Site Plan Drawing_V1.pdf Markup Summary

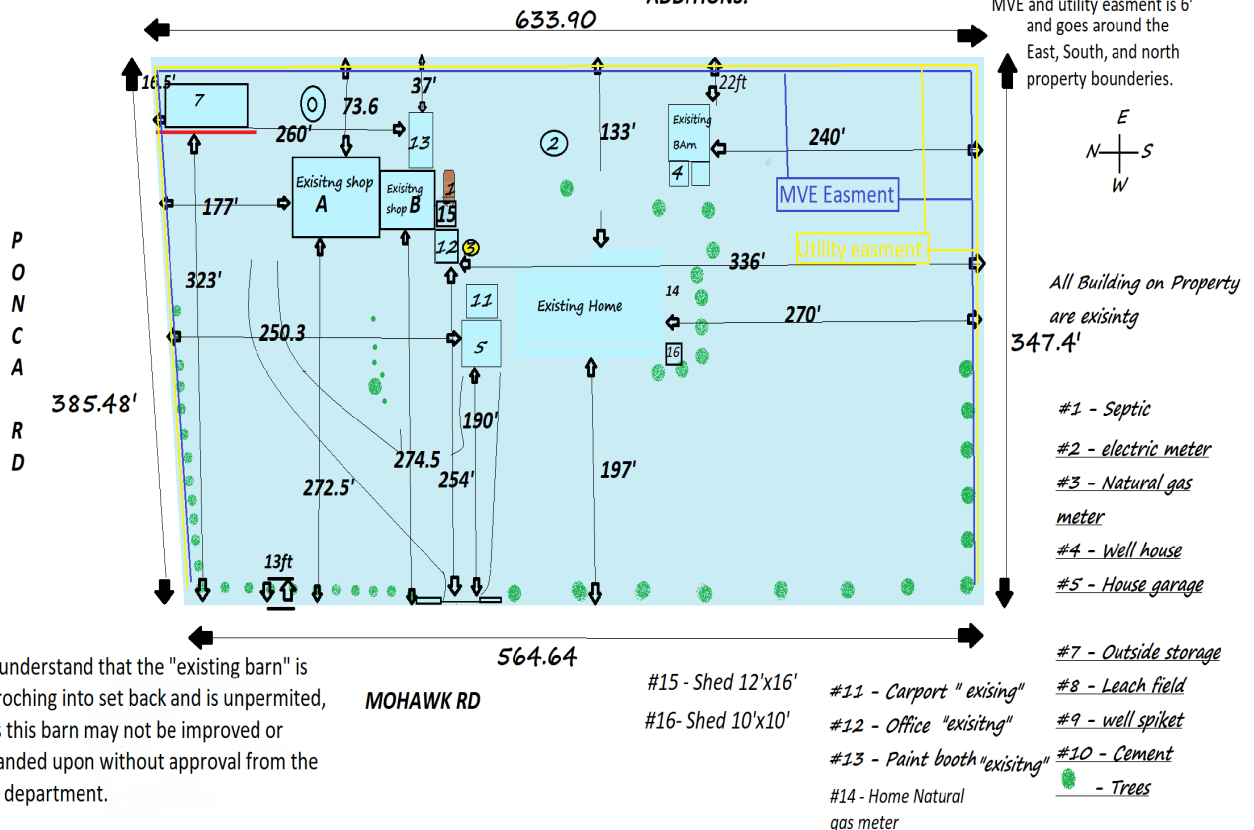
1. This "vehicle parking" area looks like outside storage in an aerial photograph. It looks to be screened with a 6-foot tall, fully-opaque fence or wall as required, but please rename this area as outside storage for vehicles' and note that it is screened per screening requirements for Outdoor Storage in chapter 5.

2. Google Earth's aerial image of property does not show landscaping along outside storage "vehicle parking"; only a fence along the property line is shown, with the landscaping stopping several feet west of the outside storage/vehicle parking area. Please revise plan to reflect what is shown on aerial if applicable.

3. While the number of trees meets the minimum required for road frontage, but the depth of roadway landscaping does not meet the requirement (see measurement of 6' below). If you will not meet the landscape depth requirement, then you may request lesser roadway landscaping depth as part of an Alternative Landscaping Plan request. Please refer to the Roadway Landscaping and Alternative Landscaping Plan sections (sections 6.2.2(A) and (B)) provided via email to castrosbodyshop1@hotmail.com on 12/29.

1. Please add setbacks from all permanent structures to property lines (barn is missing setbacks from eastern property line, for example).

2. Please also add easements as noted on the title commitment and plat. (all side and rear lot lines have 6-foot utility easement per note on the plat.)

3. Please add site data table. Please refer to site plan example and include ALL property and building information shown on that plan, shown directly on the plan or on the data table, as appropriate per the examples. Access the site plan example via this link: <https://assets-planning-development.elpasoco.com/wp-content/uploads/FAQ/SitePlanExampleSmall.jpg>

*Don't forget to include all information on site plan example, including north arrow to indicate north direction.

Please clearly label all development as proposed or existing.
